**SSD 10353 Tweed Valley Hospital Stage 2**

## Attachment A – Comments on SSD 9575 MOD 2 and SSD 10353

**Figure 2.1: Nearby Bus Services**

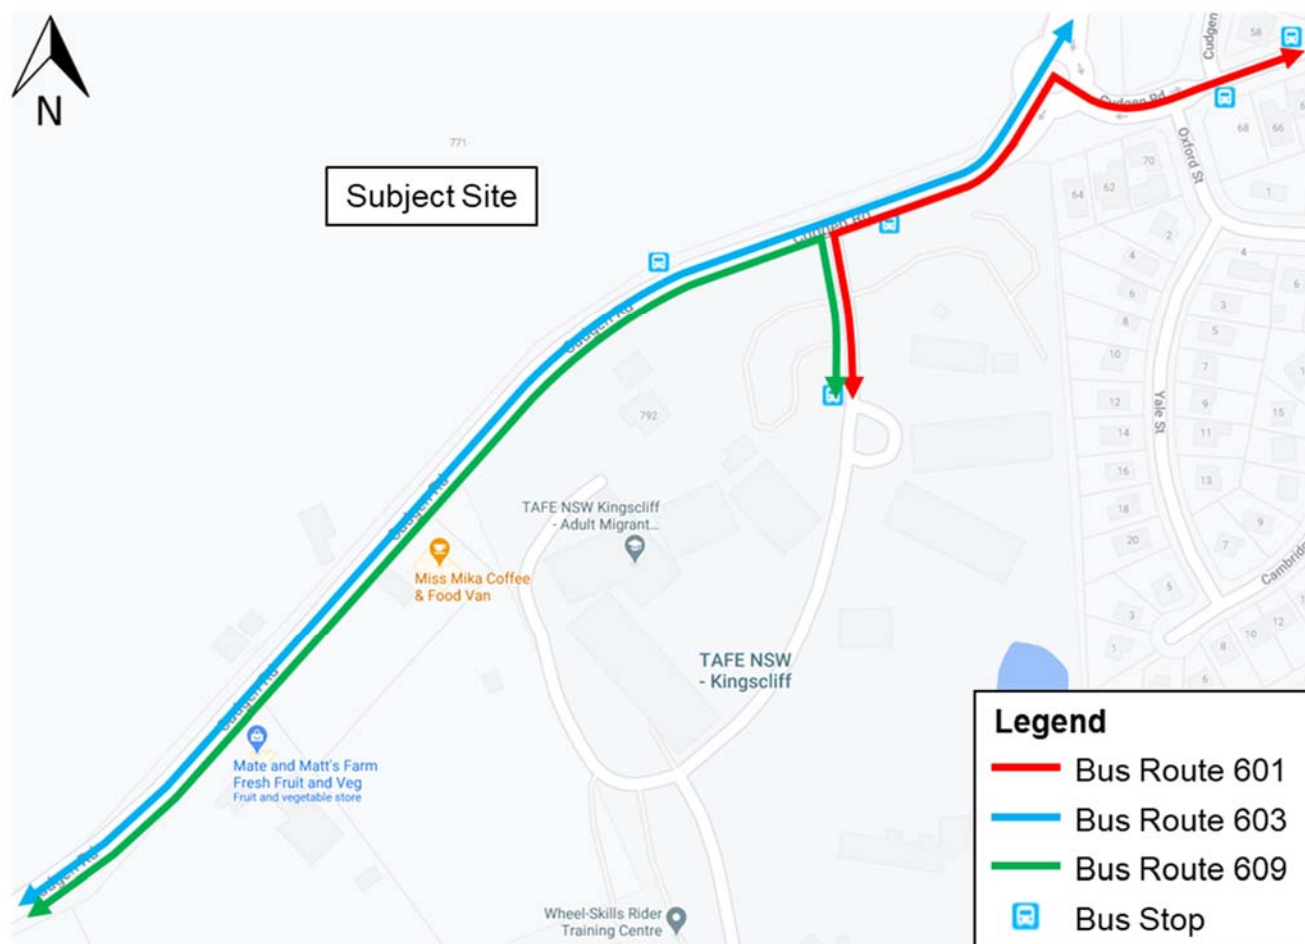
Drawings (i.e. Main Entrance – General Arrangement Plan) are provided as appendix to the Environmental Impact Statement (EIS) and Traffic Impact Assessment (TIA) report that illustrate the location of the proposed new bus stops on Cudgen Road. However it is not evident that the details of design as required in the above two conditions are adequately presented in the EIS and its associated documentation.

Details of the proposed new bus stops should be included in the drawings in support of the EIS documents to demonstrate the adequacy of the design and reference be made to the bus capable infrastructure guidelines and DDA compliance.

It is recommended that the proponent be conditioned to undertake an independent Detailed Design Road Safety Audit (RSA, refer to *NSW Centre for Road Safety Guidelines for Road Safety Audit Practices*) of the proposed pedestrian facility improvements and bus stop arrangement on Cudgen Road, prior to issue of construction certificate. The proposed design shall address any deficiencies identified within the RSA.
